CITY OF ALBUQUERQUE

RE: **7901 Las Lomas NE**
Grading Plan Stamp Date: 6/24/19
Drainage File: D16D002I

Based on the submittal received on 6/25/19, the grading plan cannot be approved until the following corrections are made:

ENGINEER'S SEAL	7901 LAS LOMAS	DRAWN BY WCWJ
	GRADING AND DRAINAGE PLAN	DATE 6-05-19
7/29/19	 Rio Grande Engineering 1606 CENTRAL AVENUE SE SUITE 201 ALBUQUERQUE, NM 87106 (505) 872-0999	2108048-LAYOUT-6-05-19
DAVID SOULE P.E. #14522		SHEET # —
		JOB # 2109049

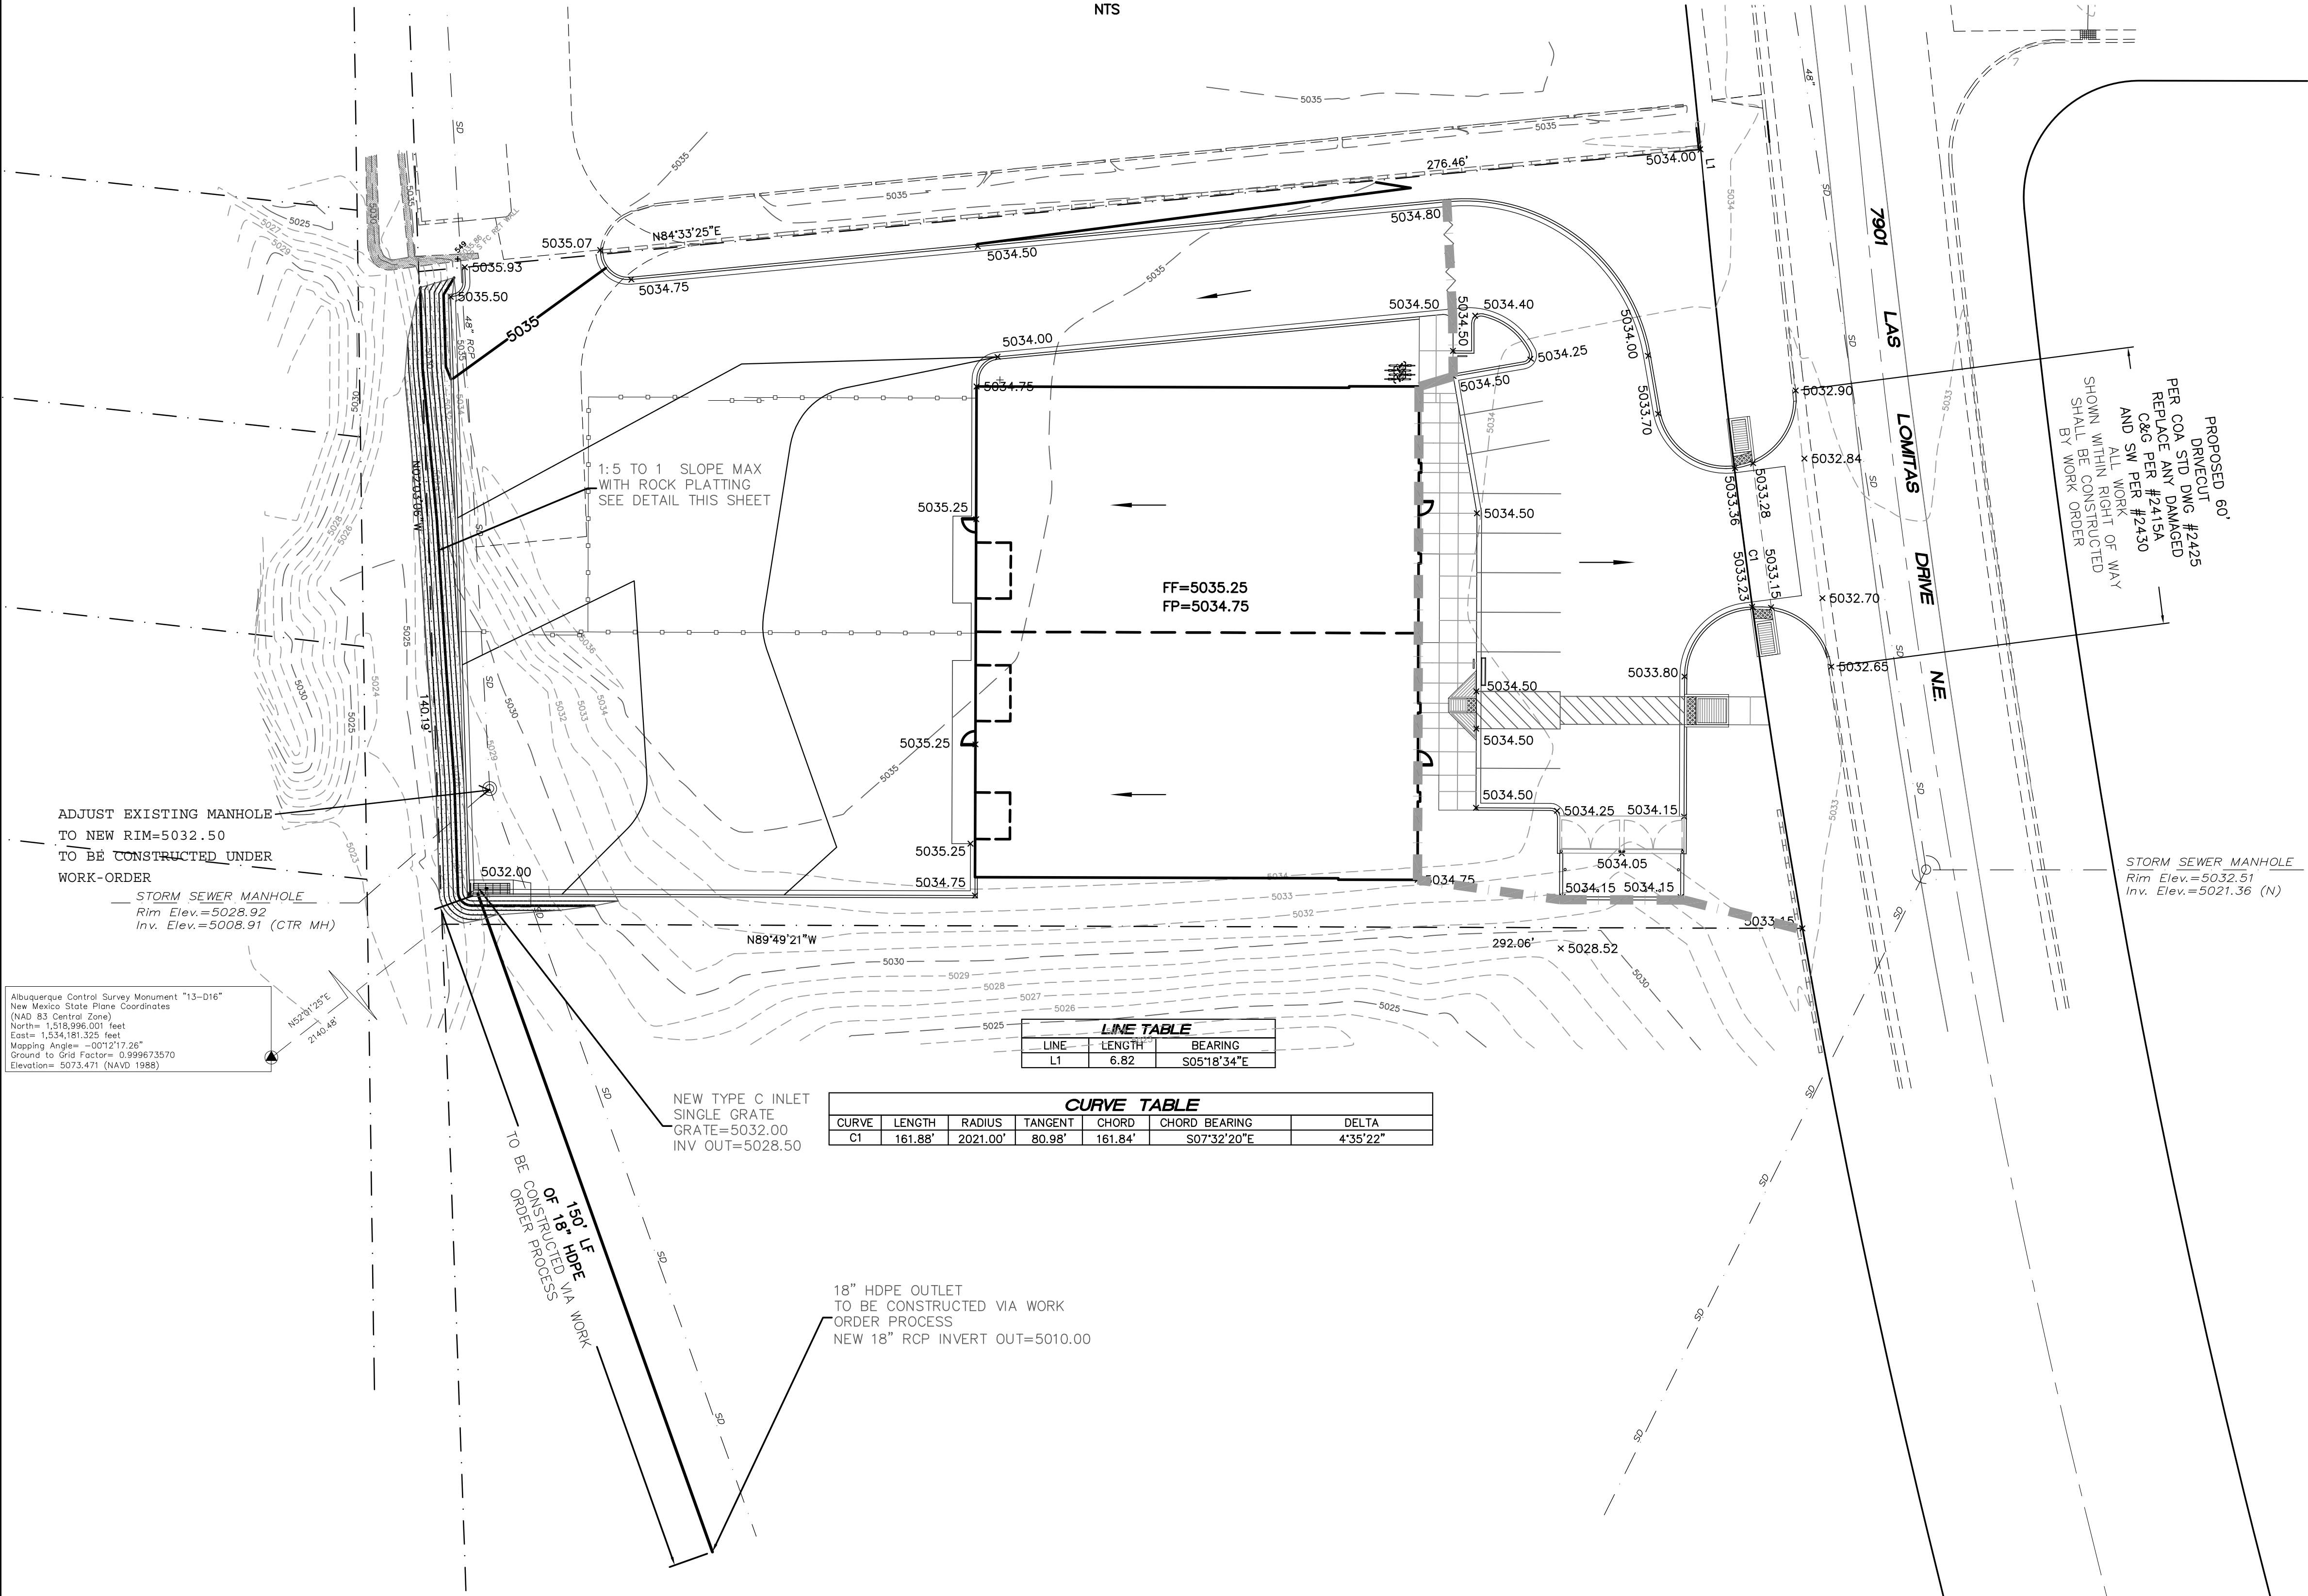
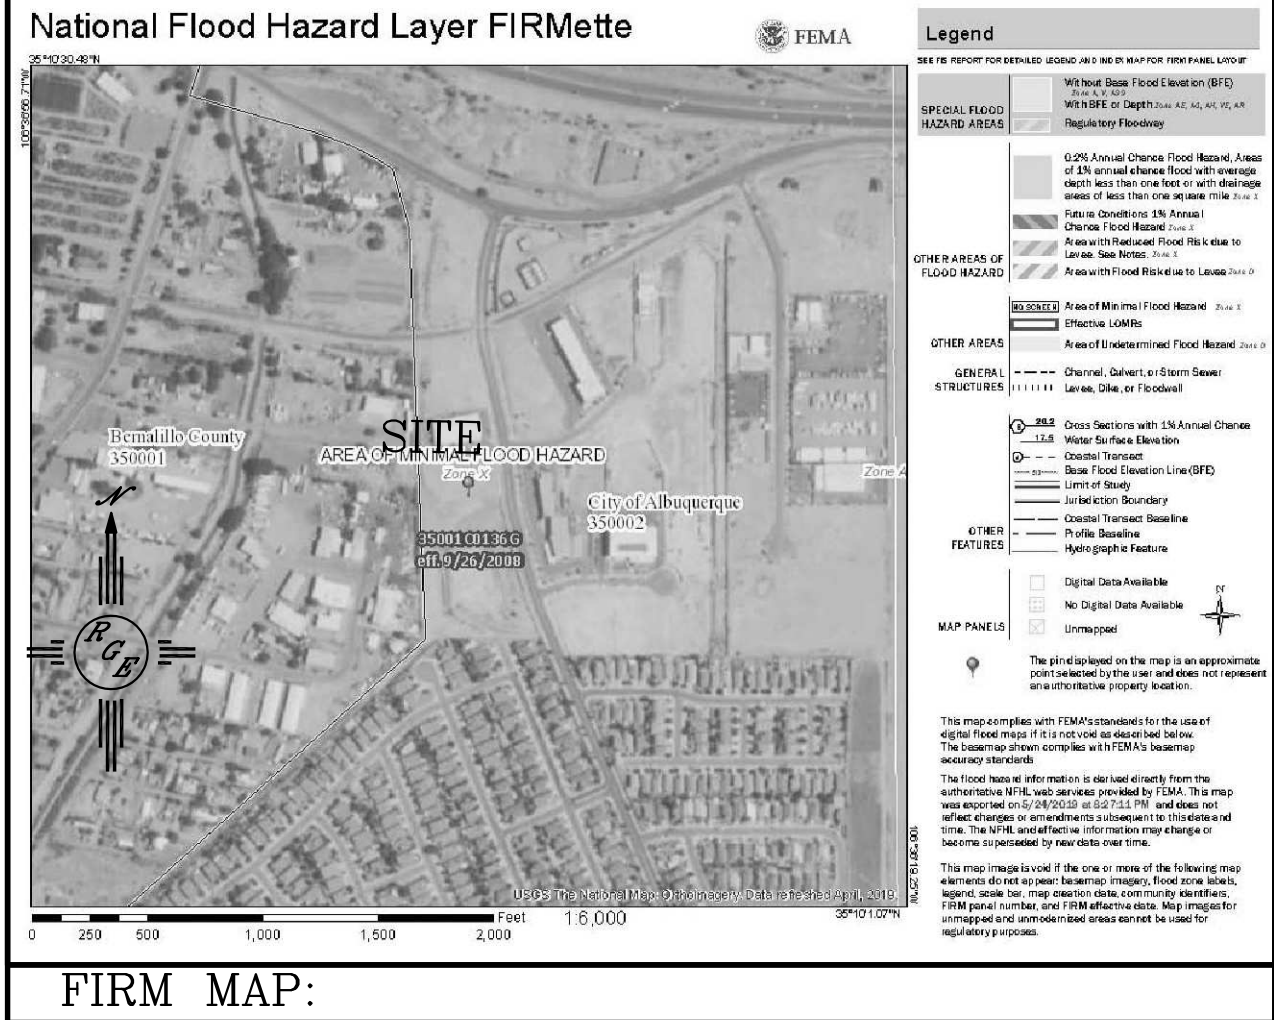
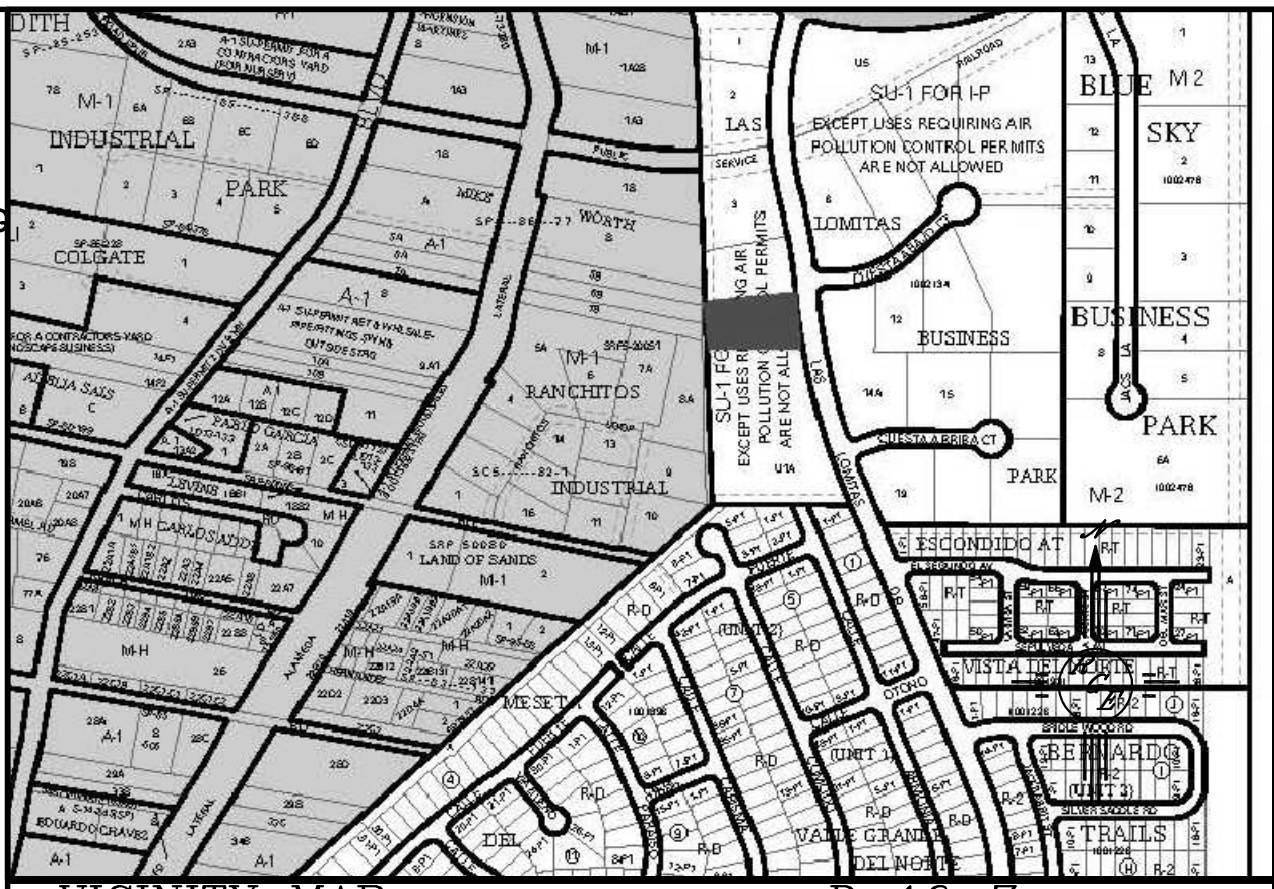
1. The manhole and storm drain on the west edge of the lot is the controlled outfall for the pond to the south. Its discharge is limited to 4cfs with an orifice plat at the pond outlet, per the Las Lomas drainage master plan (D16D002). This site cannot discharge directly to the pipe/manhole. Flows from Lot 5 need to be discharged into the pond or onto Las Lomas.

2. Show the public drainage easement for the storm drain. Annotate that "No work may be performed in the public easement/ROW without an approved Work Order". SO-19 is not an option for this work, I already asked.

3. Any modification to the manhole, such as raising the cover to the new finished grade elevation, will require a work order. Any controlled discharge to the pond, such as a rundown or drop inlet with pipe, will require a public work order. Work in the pond or to raise the manhole cover will need to be built to public standards as both facilities are public infrastructure.

4. Because a public work order (non-IIA) is most likely required, it will need to include all of the work in the ROW/easements, such as the driveway cut, ADA ramps, and utility cuts (if any).
